RESPONSE TO NOTICE OF EXHIBITION – SSD 6603 Site 68 SYDNEY OLYMPIC PARK

The Sydney Olympic Park Authority (SOPA / the Authority) supports the proposed development and believes that the proposal generally complies and contributes to the vision of a vibrant township as outlined in the Sydney Olympic Park Master Plan 2030.

Figure 9: Site 68 landscape plan showing location of bioretention systems

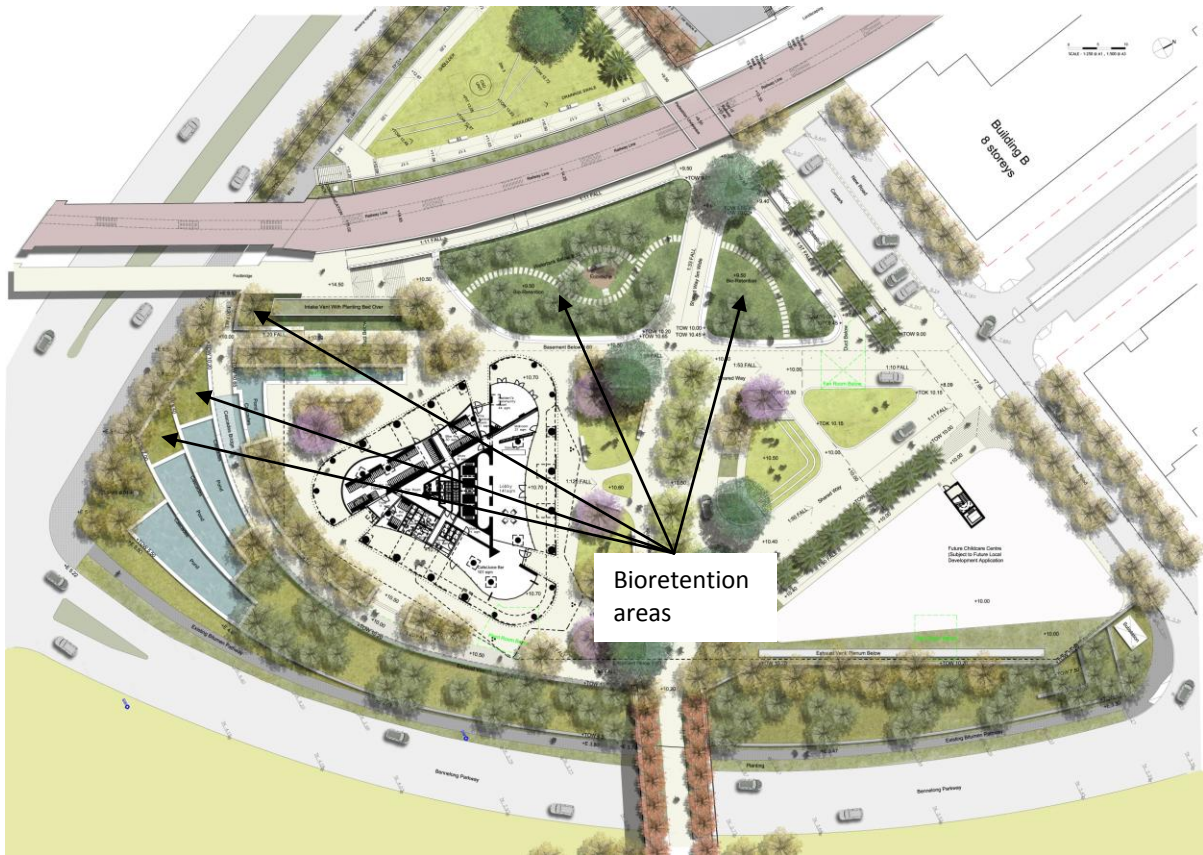
1. The proposed 'Phoenix Palms', are at risk from 'Fusarium' infection (root pathogen), and provide roosting sites for the Australian White Ibis which are considered a pest avi-fauna species. Only healthy trees should be relocated to the child care frontage. Alternatively, a more suitable tree /palm species could be nominated.

2. Larger scale alternative species of shade trees should be considered in place of Chinese tallow tree (*Sapium sebiferum*), which is out of scale with residential tower.

3. Legend does not show 'Existing trees for protection' or Existing trees for removal'
4. Street trees shown in Parkview New Street (Road 3) should be noted as 'future proposed trees by others'.

5. Legend is to include existing and proposed public area lighting. New lighting is to meet relevant Australian Standards and UEDM lighting category (P/V) standards.

6. The following are to be confirmed for the Water Feature / Cascade Pond:
 - a) Species for all bio-retention areas and irrigation systems.
 - b) Compatibility of stepping stones pedestrian access and seating niche with wetland plantings.

- c) Linings and materials of cascade ponds and bridge.
 - d) Location of pumps, filters and control room/chamber.

APPENDIX C: APARTMENT AREA SCHEDULE

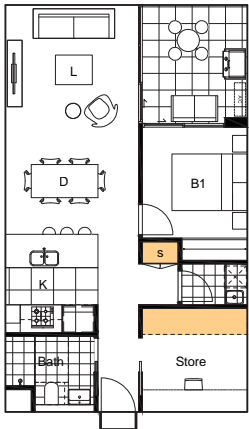
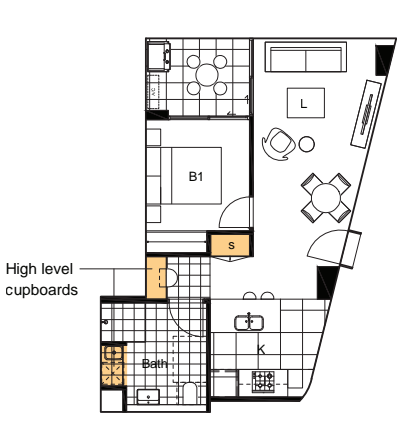
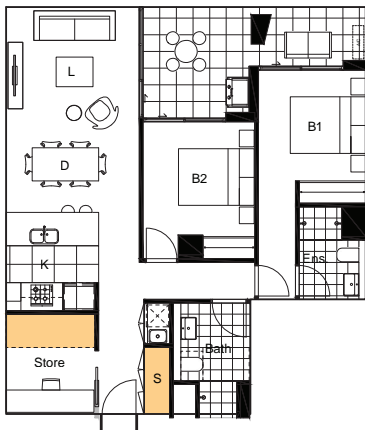
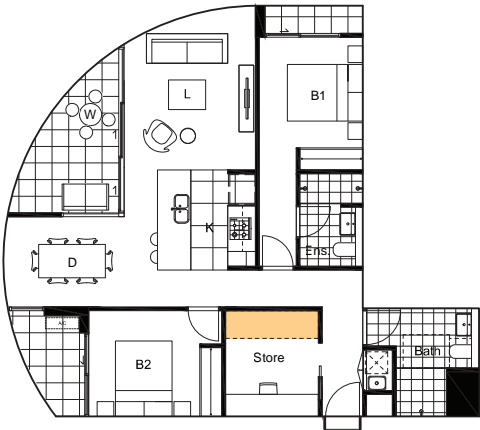
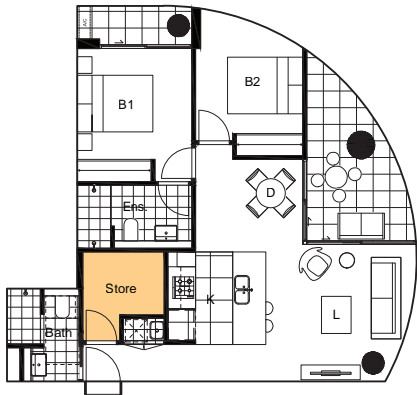
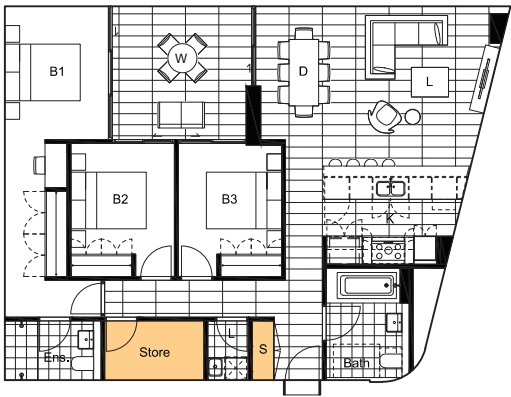
It appears that some of the proposed storage for certain types of Units falls significantly short of the required storage space and no specific details are given in relation to the amount of basement storage to be provided for each unit type (pg. 62 Appendix C).

SHADOW STUDIES

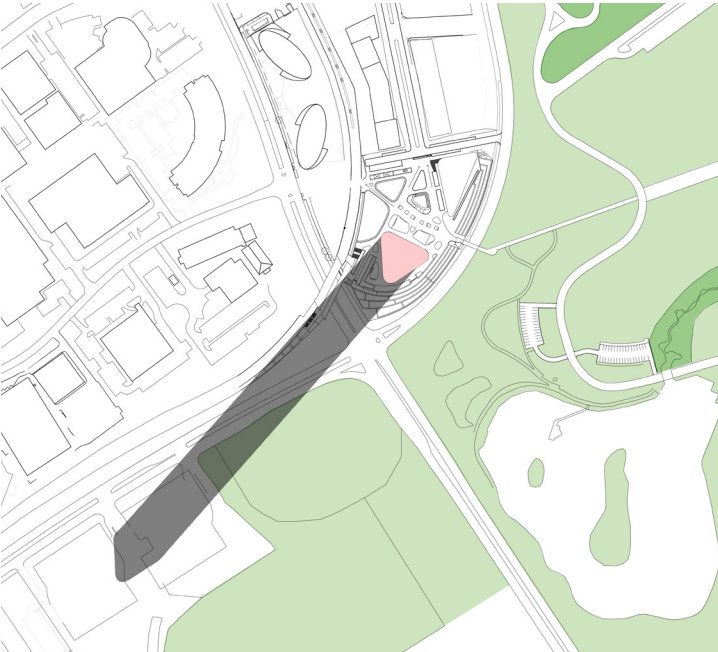
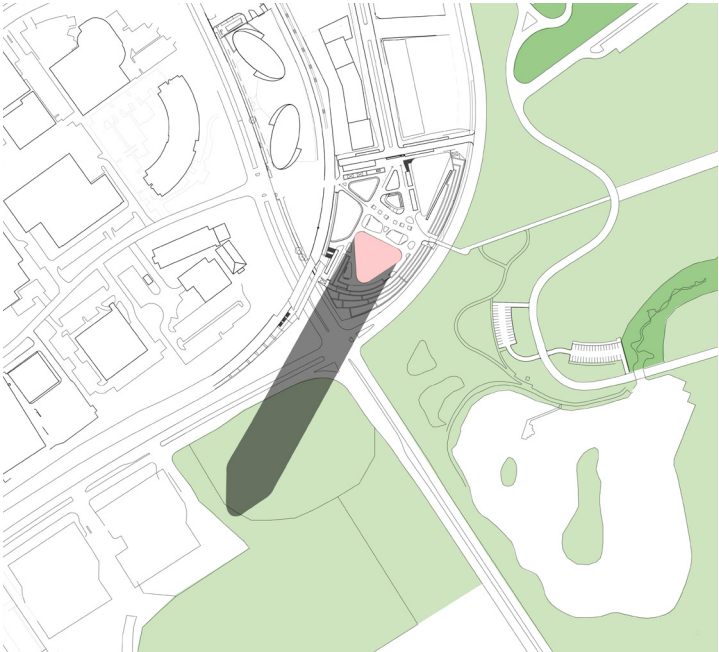
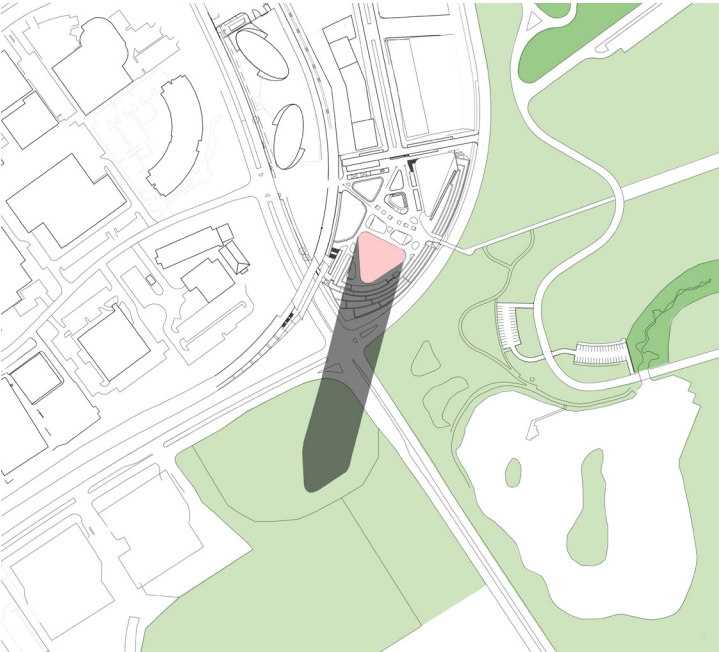
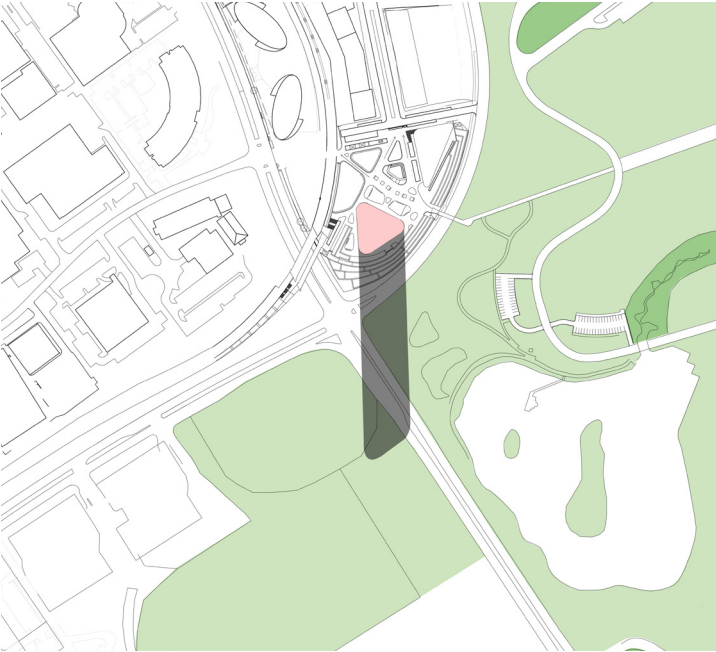
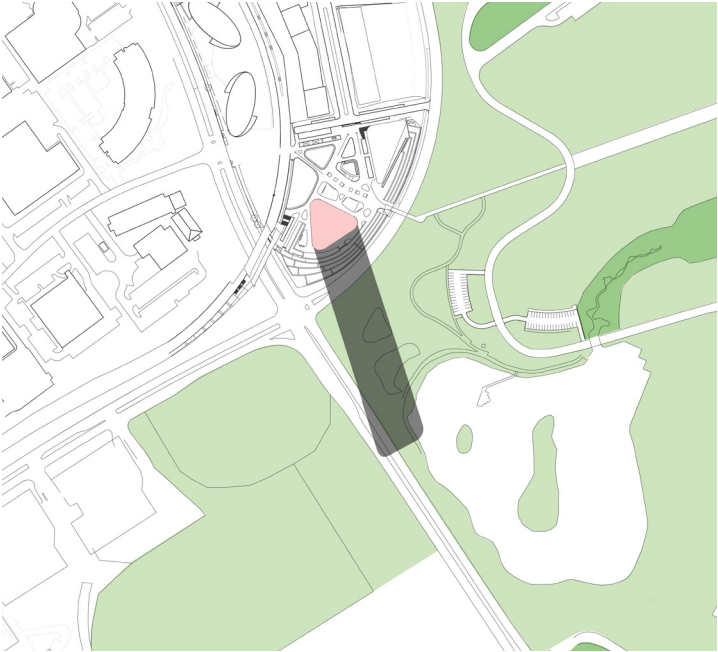
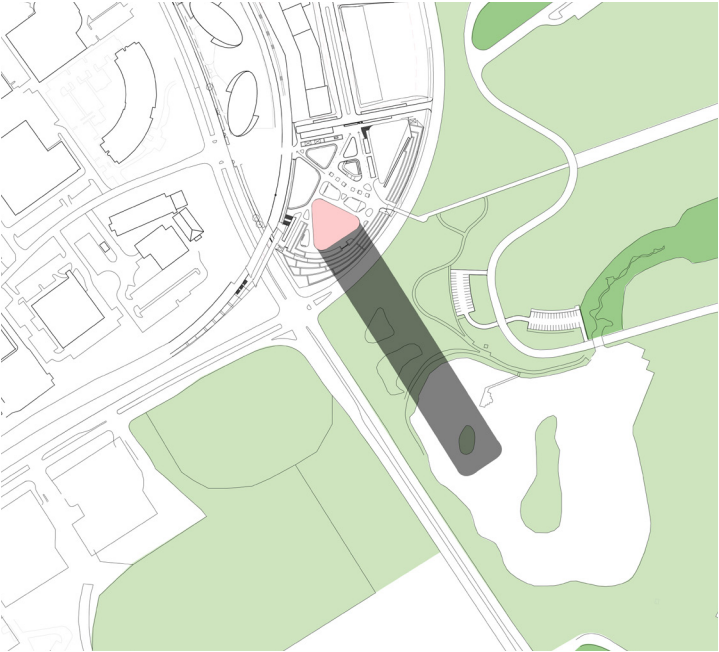
The proposed development provides an assessment of solar access between 9am and 4pm. The proposed development should provide an assessment between 9am and 3pm (as per MP 2030) and provide justification if the 70% target is not achieved.
